A12 Chelmsford to A120 widening scheme

TR010060

9.35 Applicant's Comments on Colchester City Council's Local Impact Report

March 2023

FIGURE 12.8

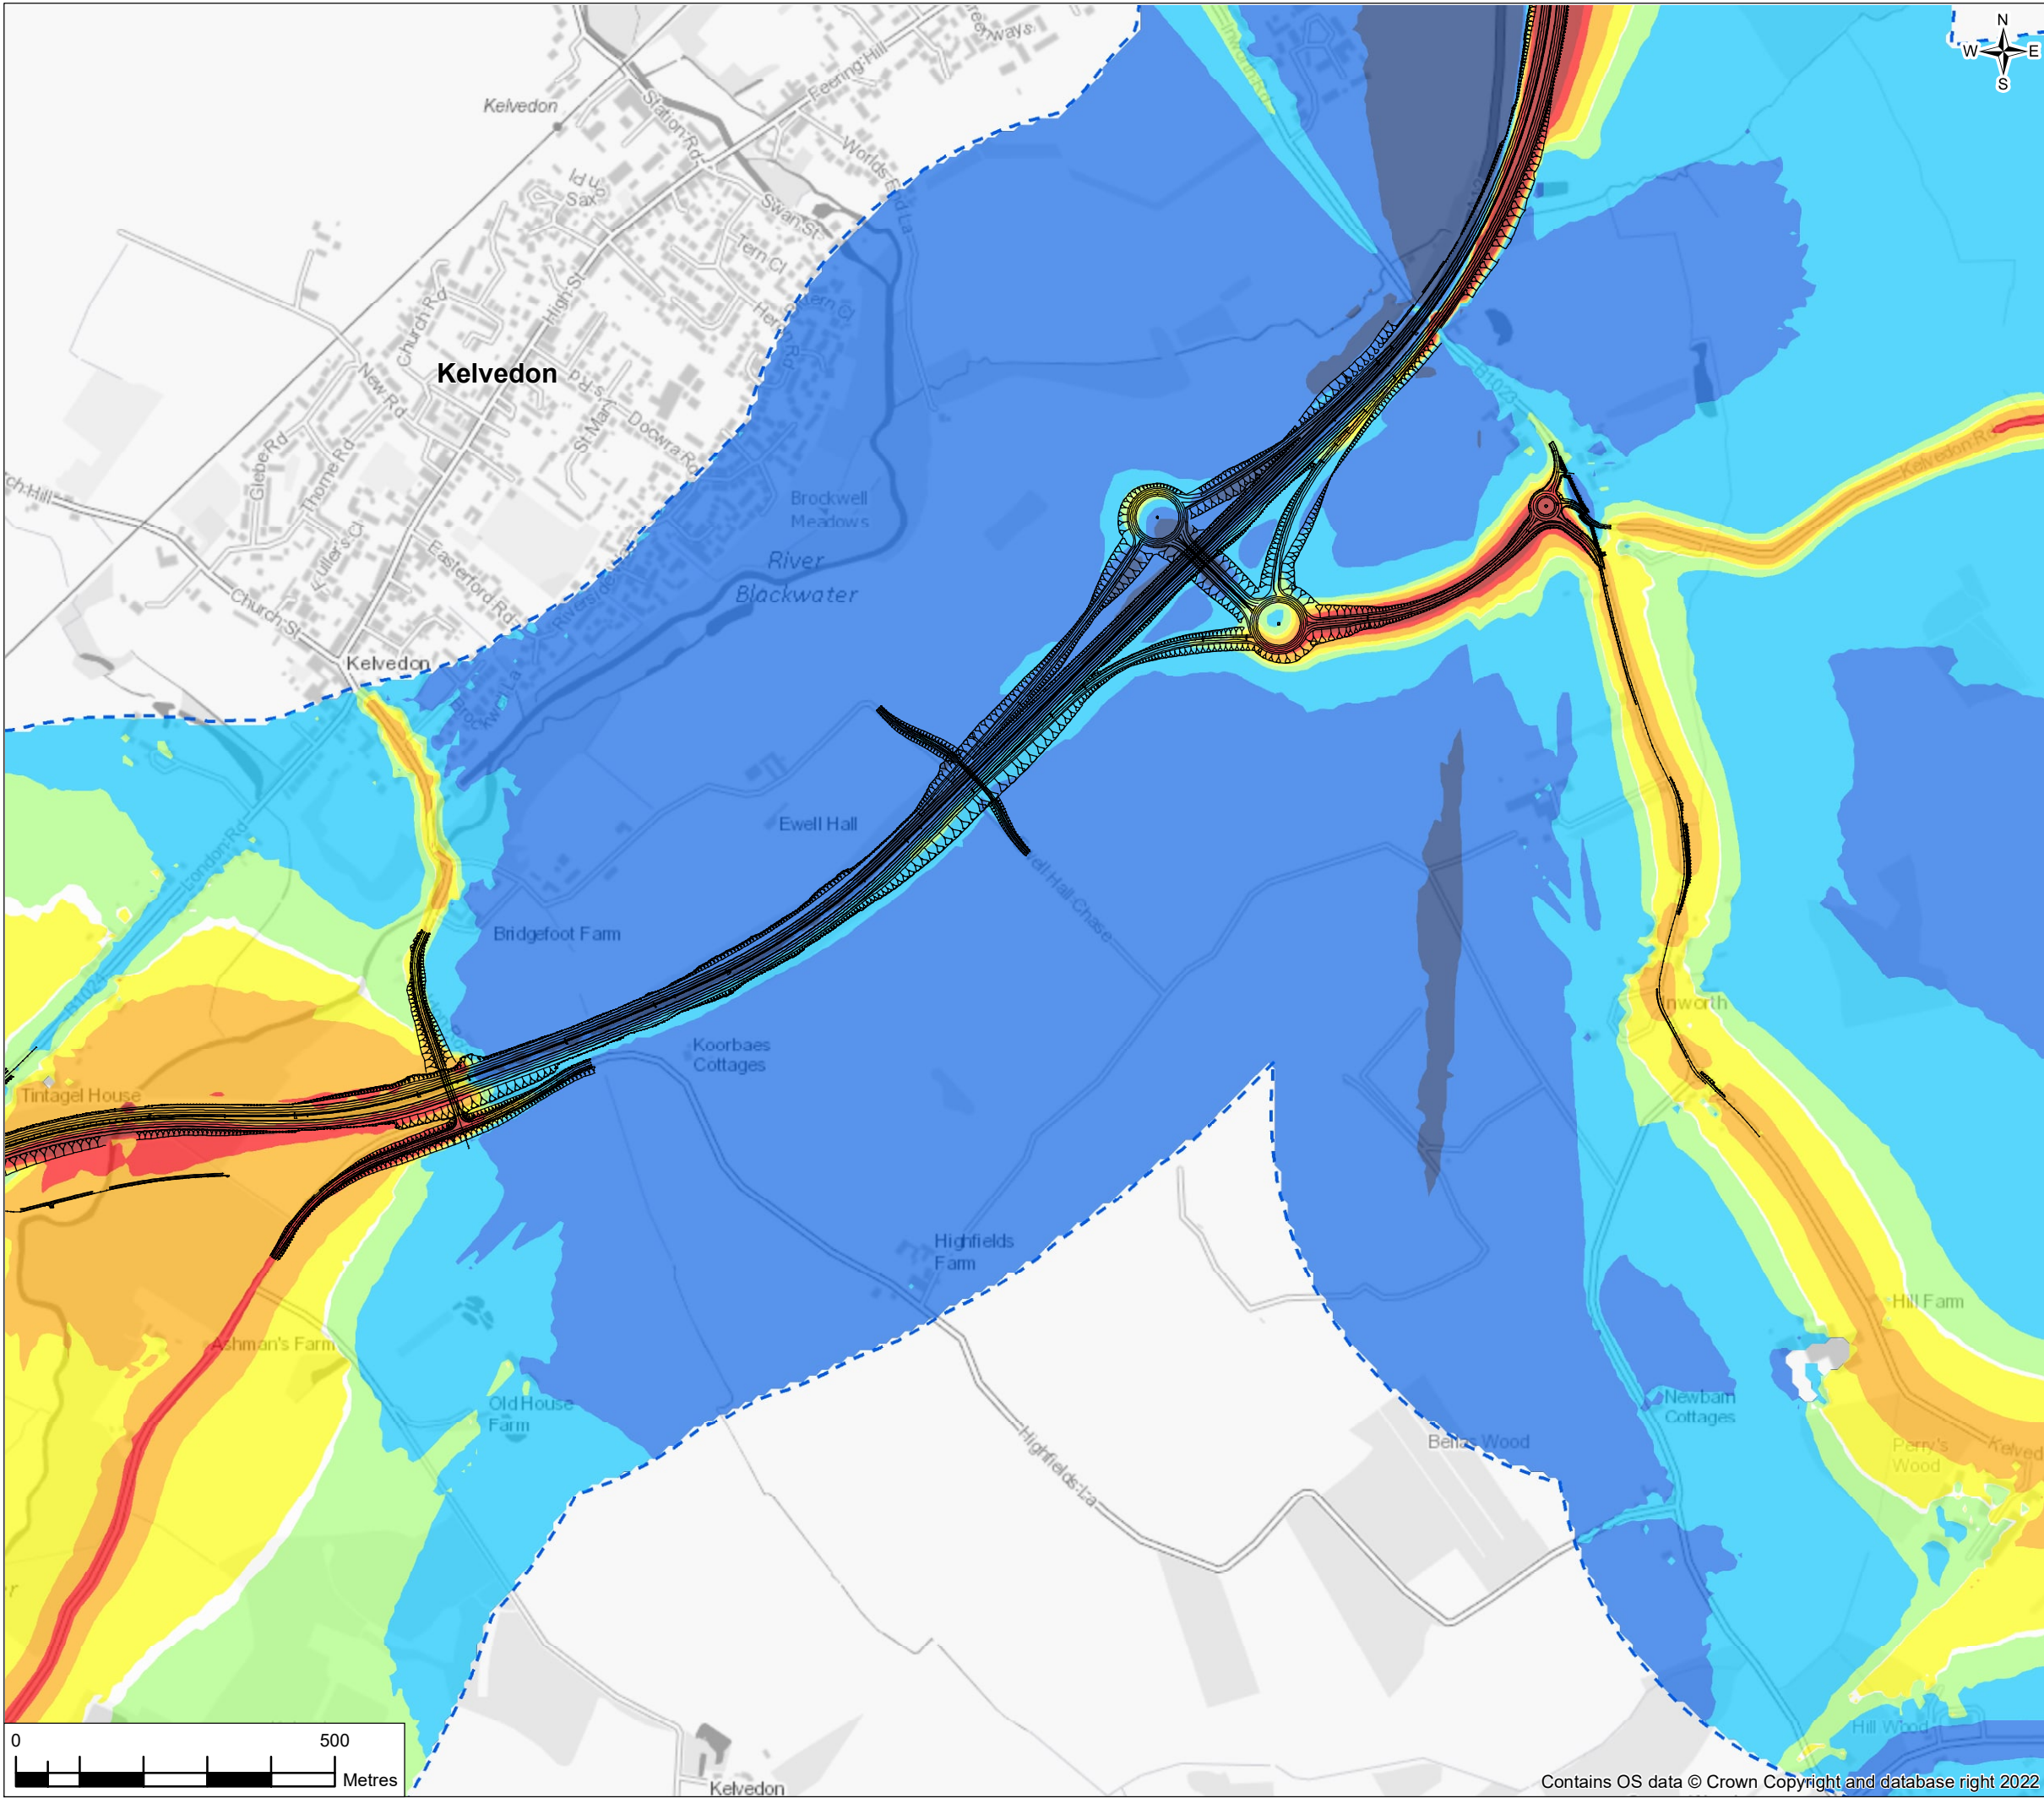
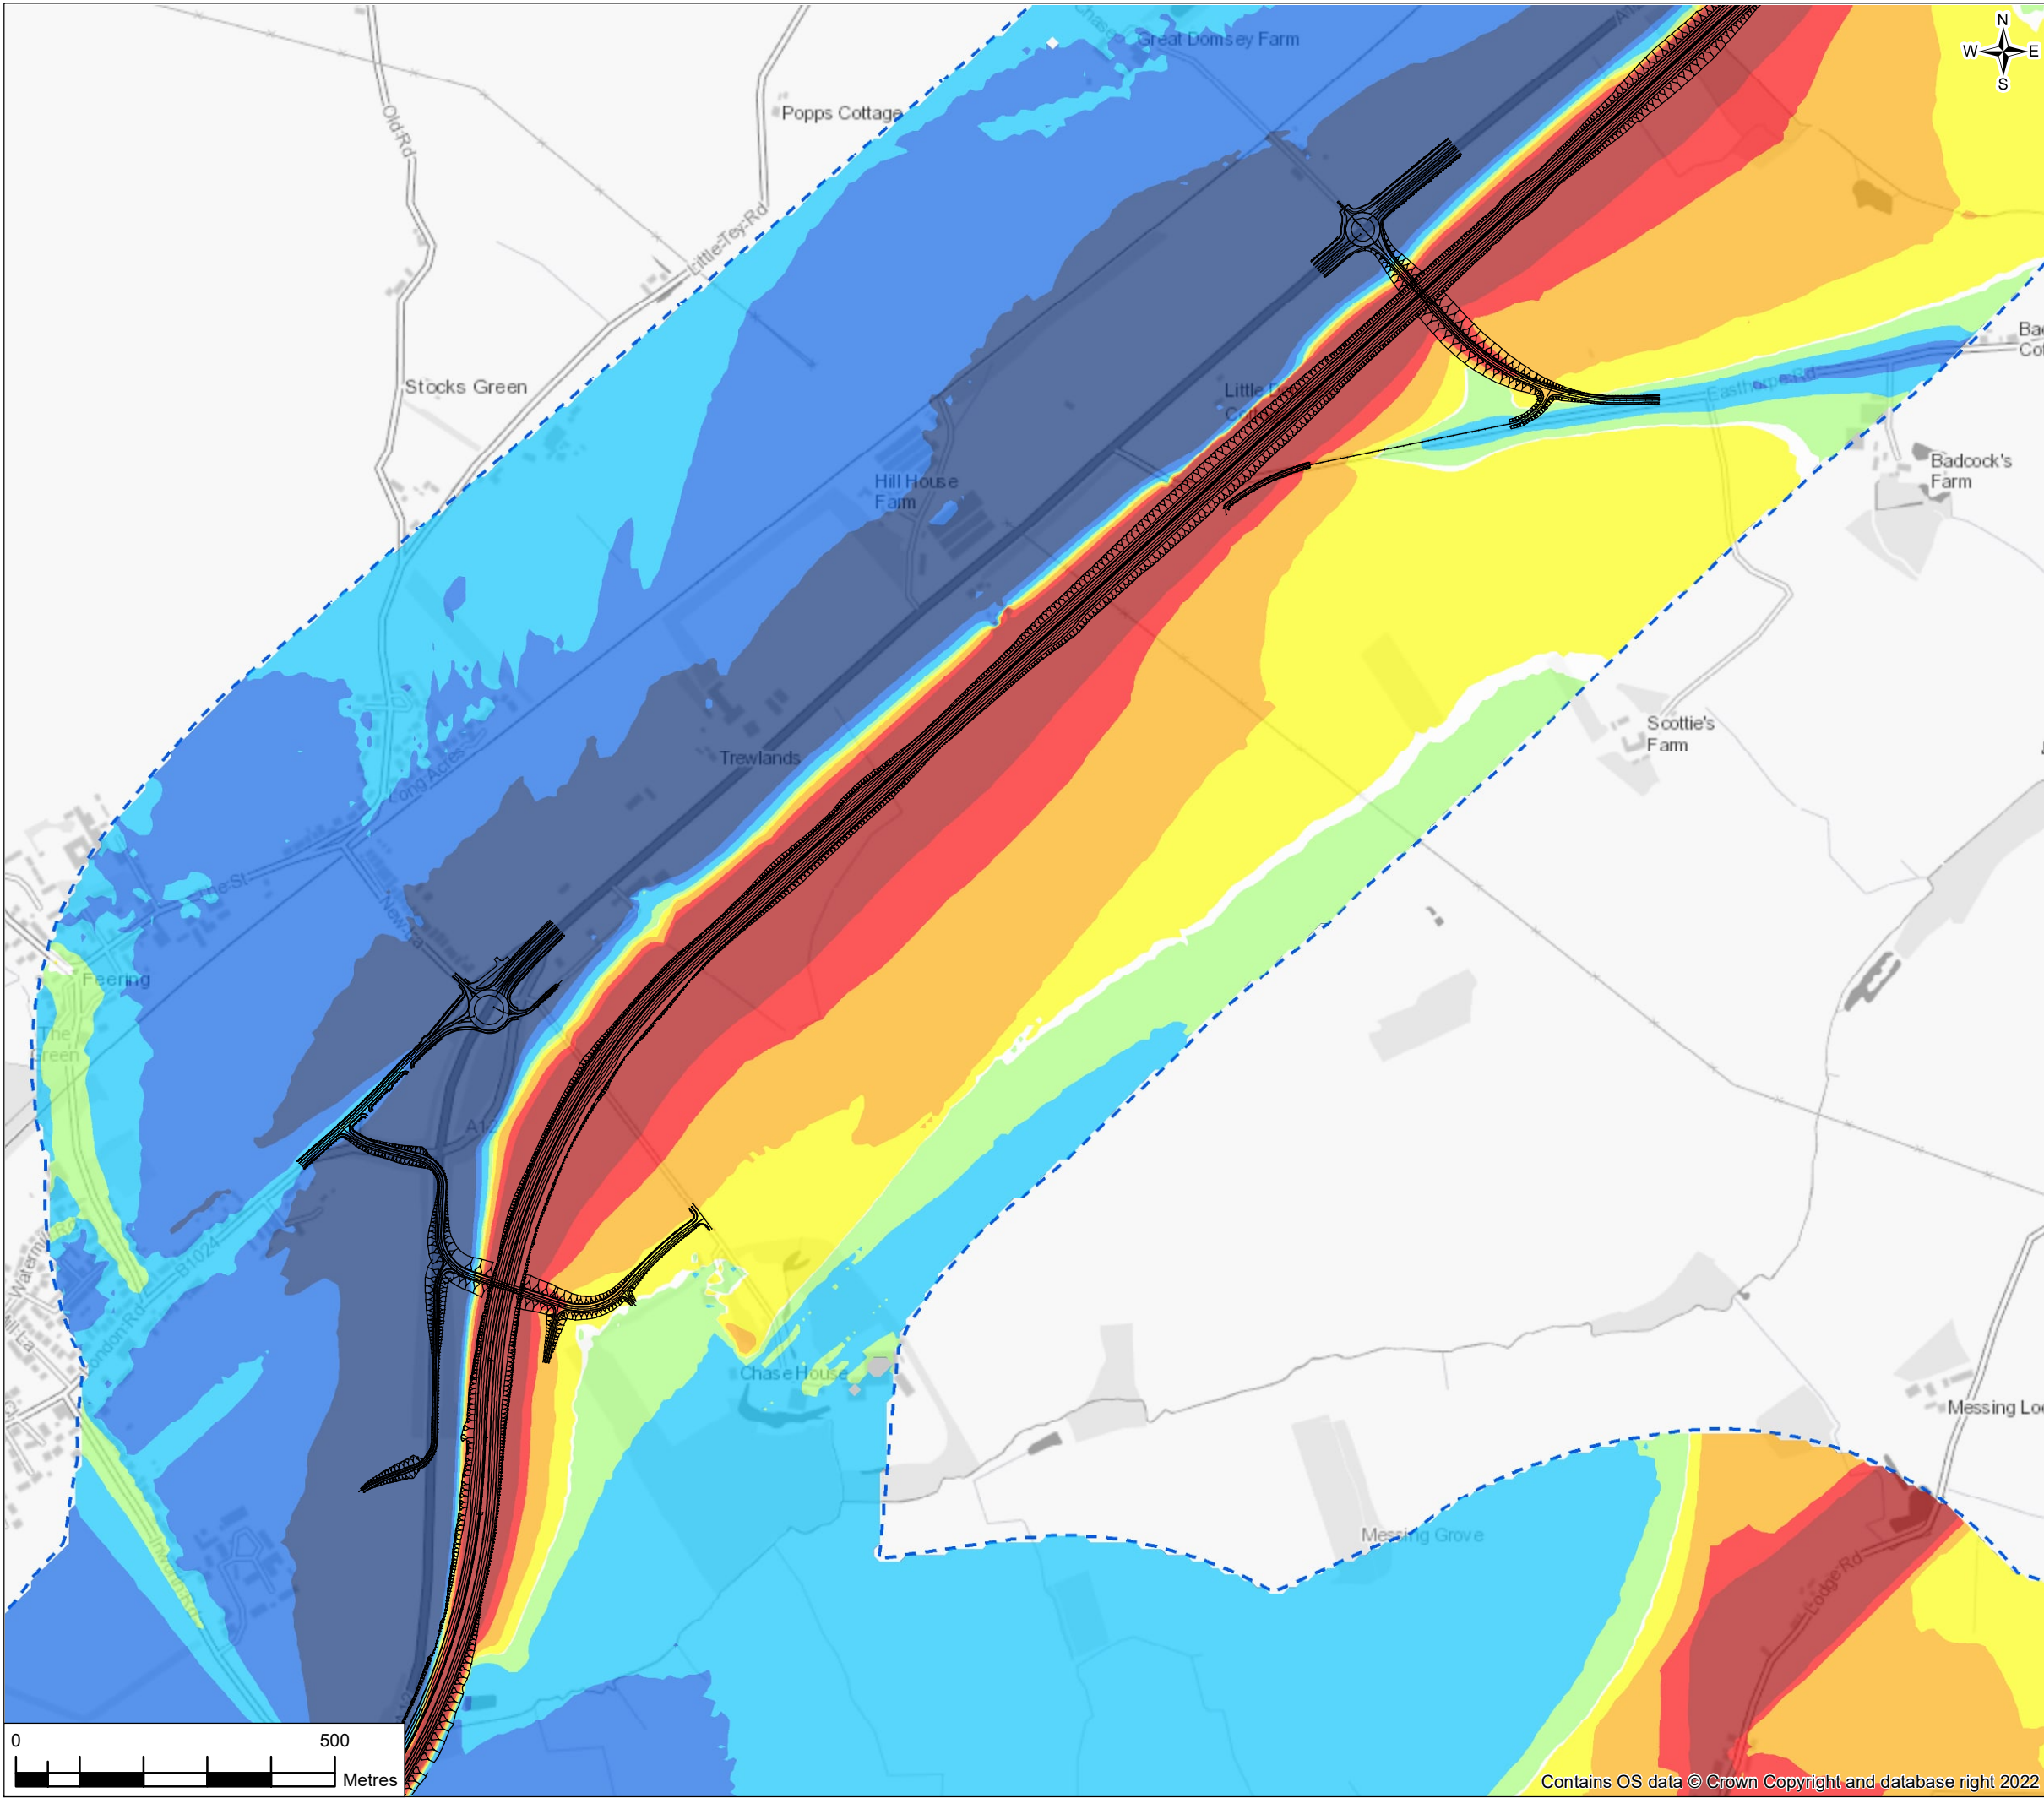
In relation to noise, noise levels would generally increase along the B1408 between 0.1dB and 0.9dB in the opening year, with some receptors adjacent to the road experiencing an increase between 1dB and 2.9dB, as shown on Figure 12.8 of the Environmental Statement [APP-235]. These are negligible and minor increases in noise respectively (see Table 12.11 in Chapter 12: Noise and vibration, of the Environmental Statement [APP-079]). However, there would be seven dwellings within Copford where the absolute noise level would be just above the Significant Observable Adverse Effect Level (SOAEL) and there would be a 1.0dB(A) (minor) increase in noise (see paragraph 12.11.55 in Chapter 12: Noise and vibration [APP-079], and Figure 12.5 of the Environmental Statement [APP-232]). In accordance with DMRB LA 111, these would experience significant adverse effects due to increases being above the SOAEL. It is not possible to mitigate these significant effects using standard noise mitigation measures for the following reasons:

- A low noise surface is only considered to be effective by DMRB LA 111 when average speeds are above 75km/h. The average traffic speed along this part of London Road is predicted to be 40km/h.
- To be effective, a noise barrier needs to be unbroken. In an urban situation such as London Road, where access is required to sensitive receptors via London Road, it is not possible to have a barrier that is unbroken.
